CITY OF ALBUQUERQUE

March 27, 2017

**RE: Coors Pavilion Subdivision Lots 2 & 3
9154 Coors Blvd
Grading Plan
Engineer's Stamp Date: 3/1/2017
Hydrology File: G11D069A**

**LOTS 2 & 3
GRADING & DRAINAGE PLAN**

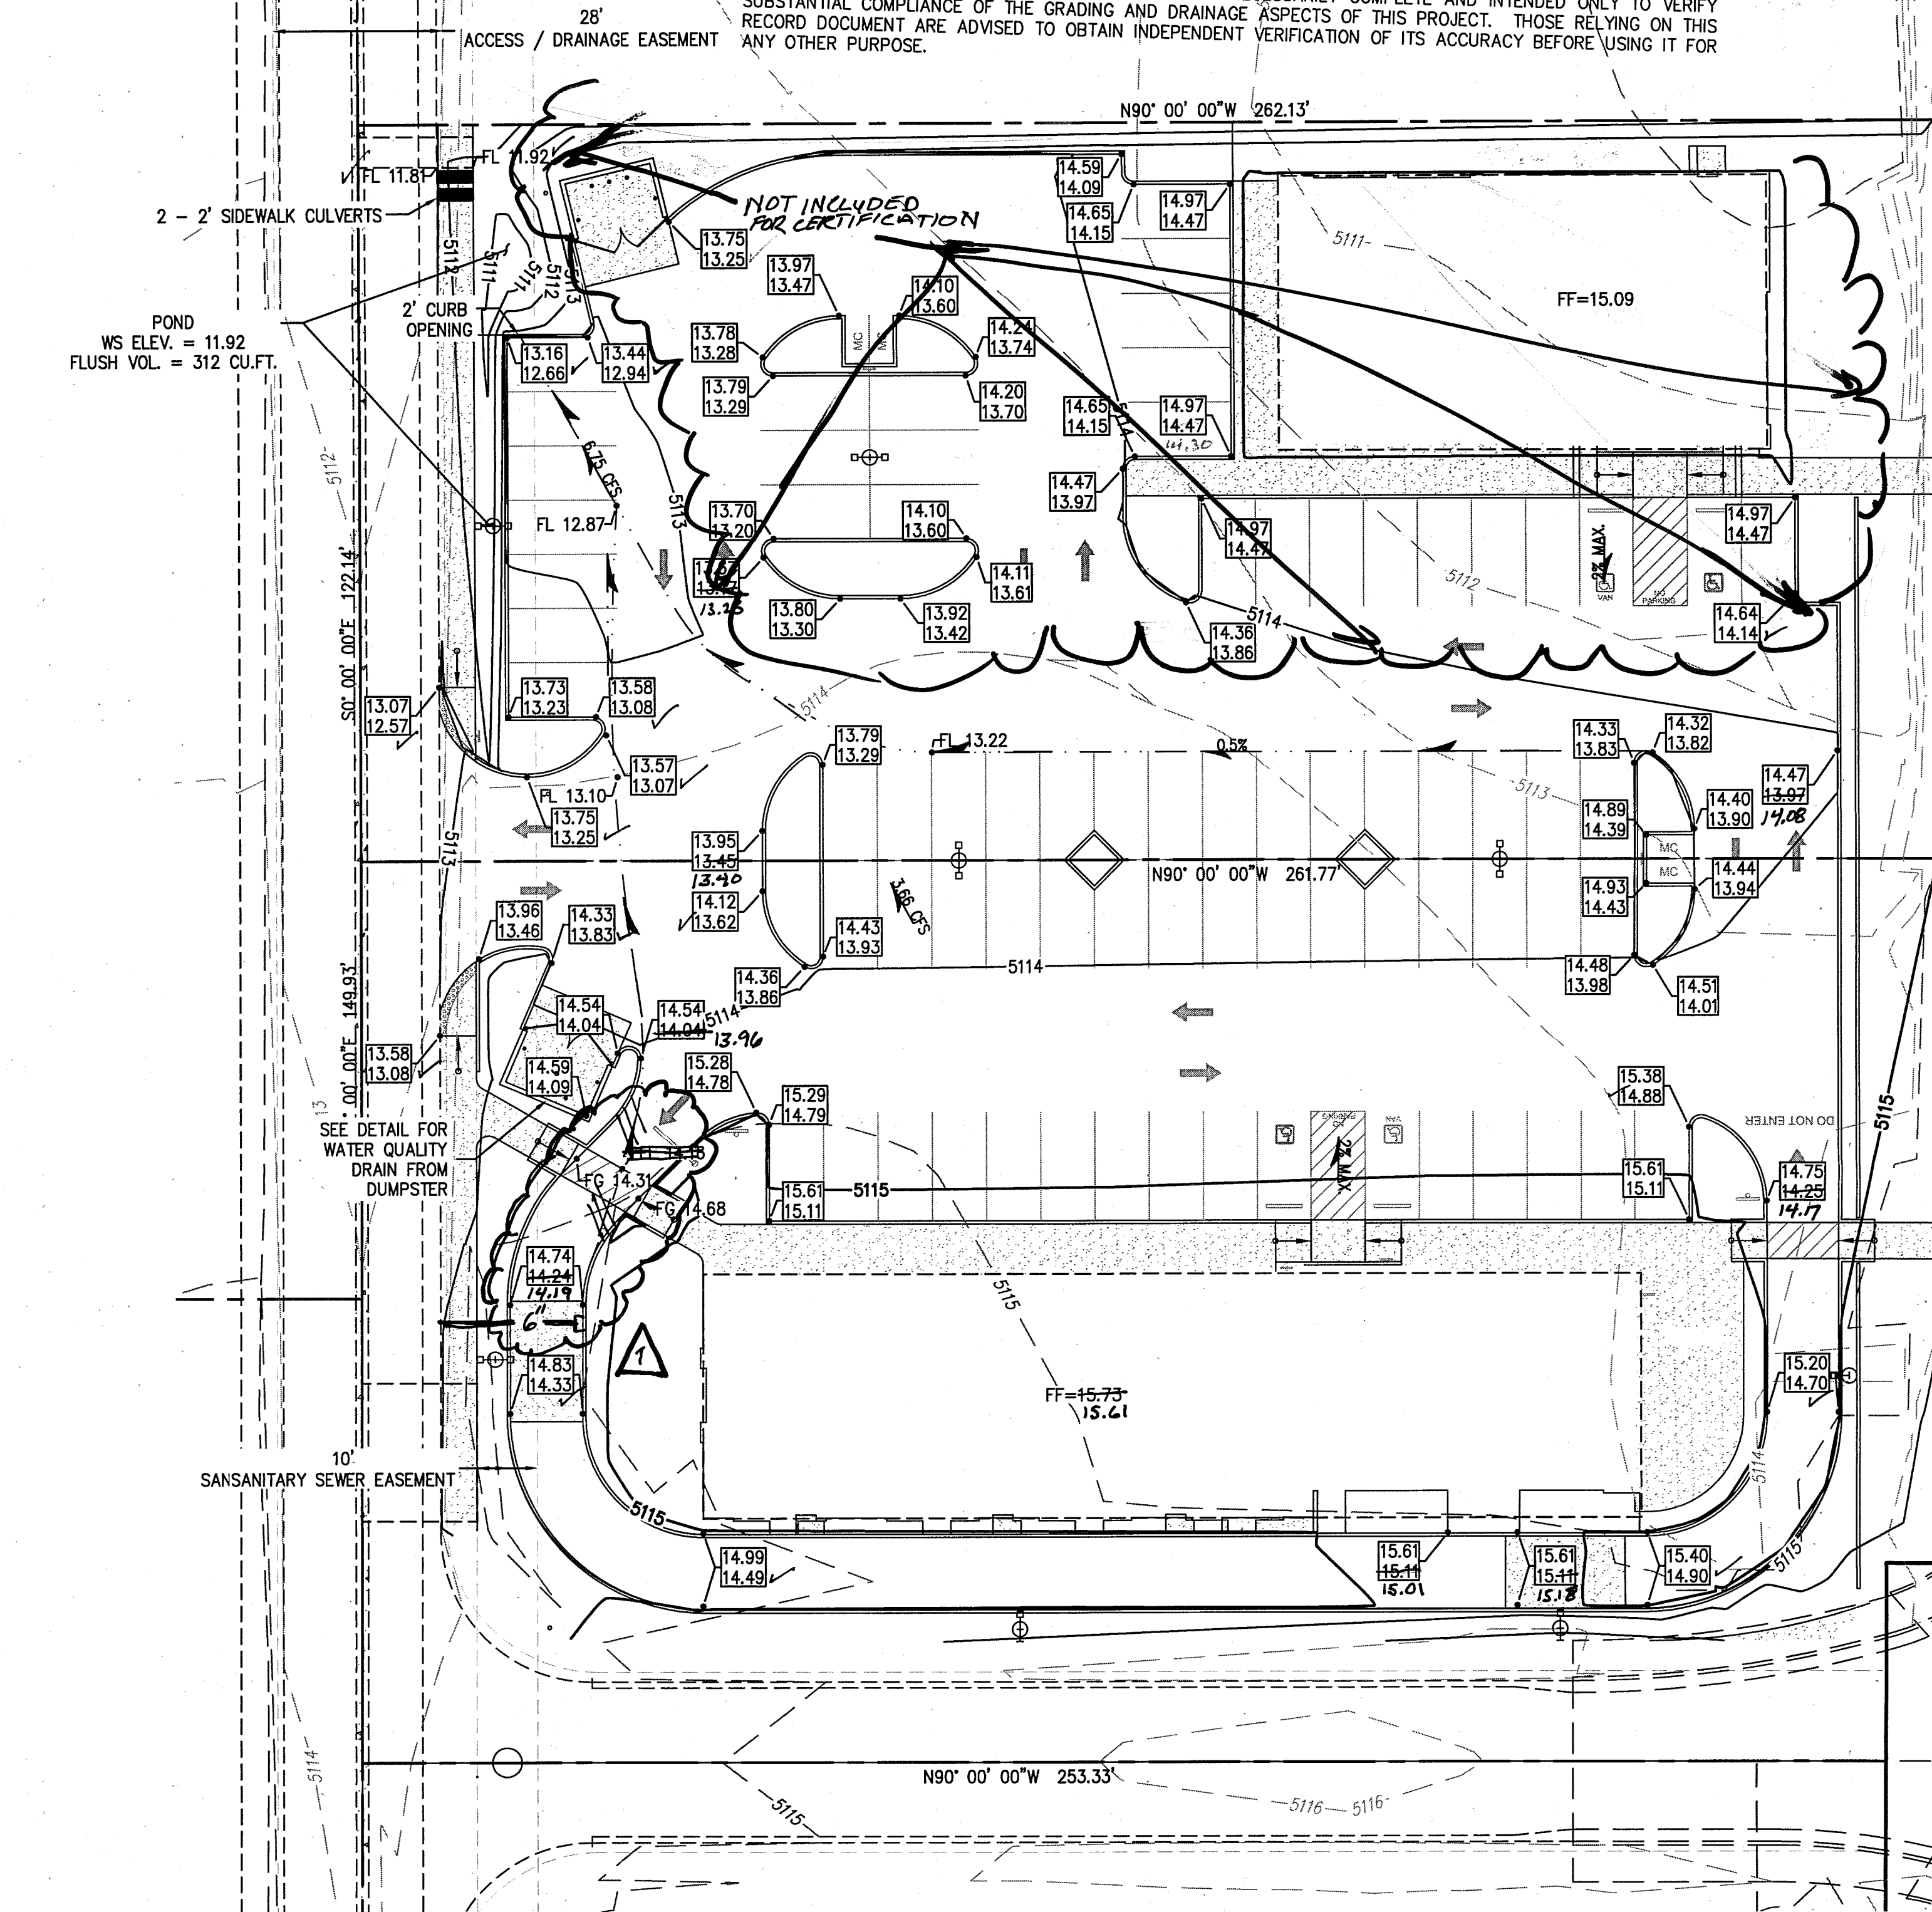
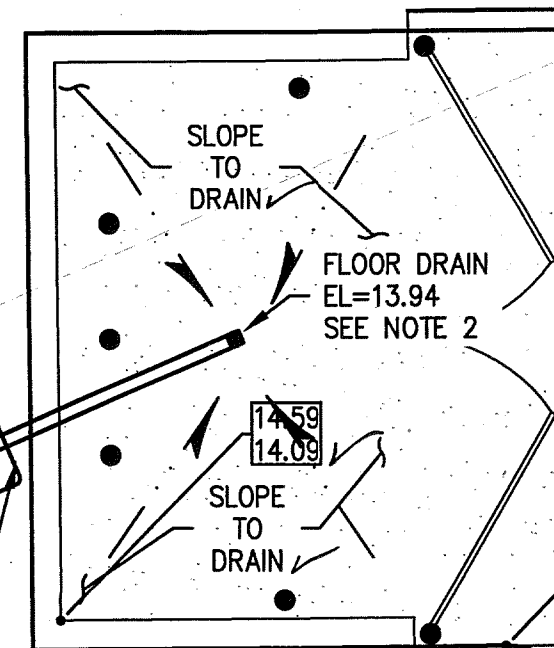
1. Prior to Final Plat, a cross-lot drainage easement will be required for Lot 2 for the benefit of Lot 3.
2. Are either of these buildings restaurants? If so, provide trash enclosure containment and drainage through a grease trap and into the sanitary sewer.
